Fire Marshal Division

RE: 26 Avery Pond Drive
Fuquay Varina, NC 27526

Application Number FMFW2002-0007

LGI Homes - Grand Opening - 40' x 50' Tent

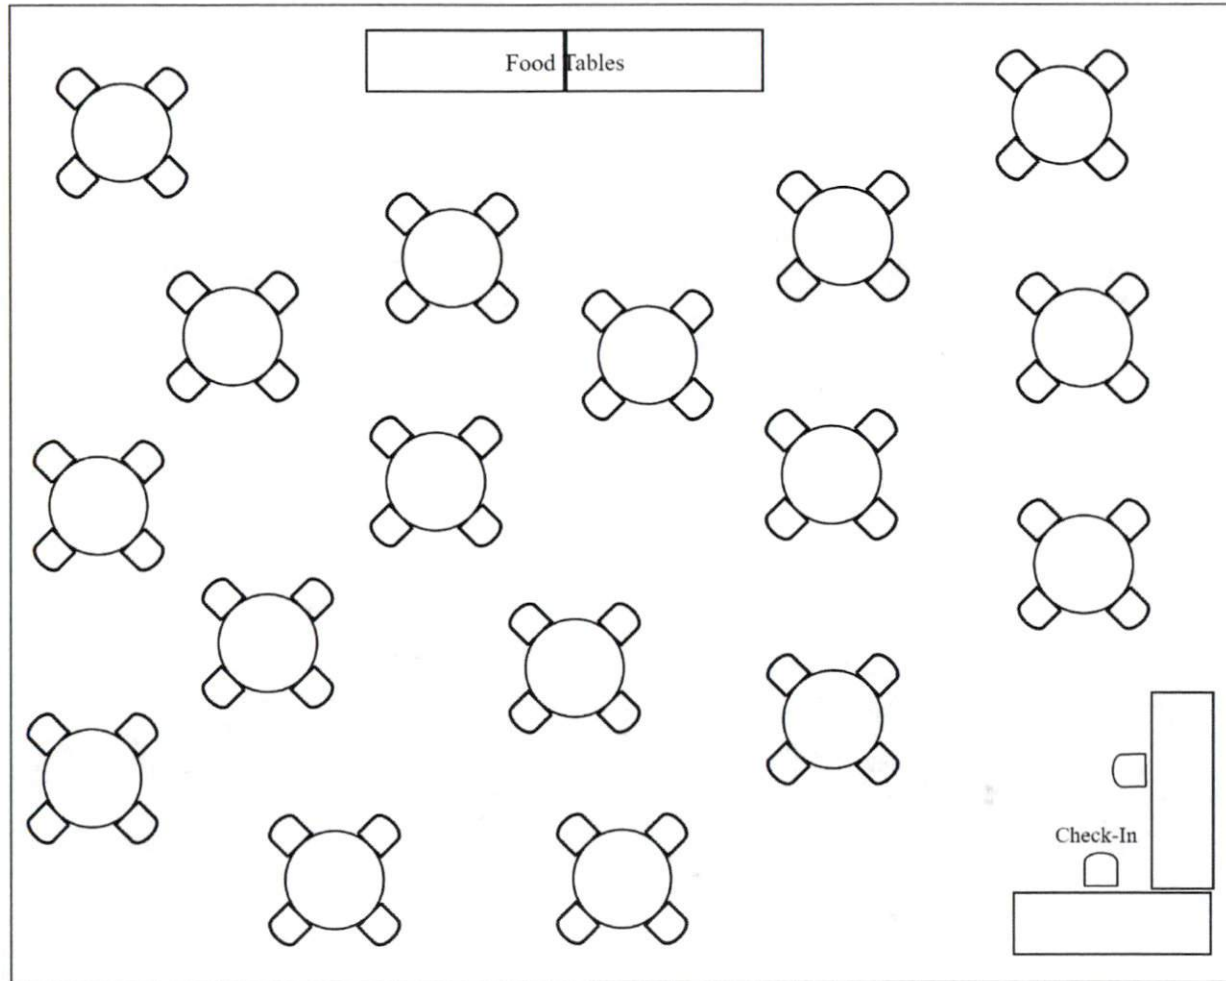
- **Exits**
 - Exits shall be clearly identified by approved exit signs.
 - The required exits shall be maintained at all times to the public way.

- **Open Flames**
 - No open flame devices are allowed under the tent.

- **Generators**
 - Generators shall be separated from the tent by a minimum of 20 feet.
 - Generators shall be isolated from contact with the public by approved means.

- **Access**
 - Tent shall be placed to allow approved fire apparatus access in the event of an emergency.
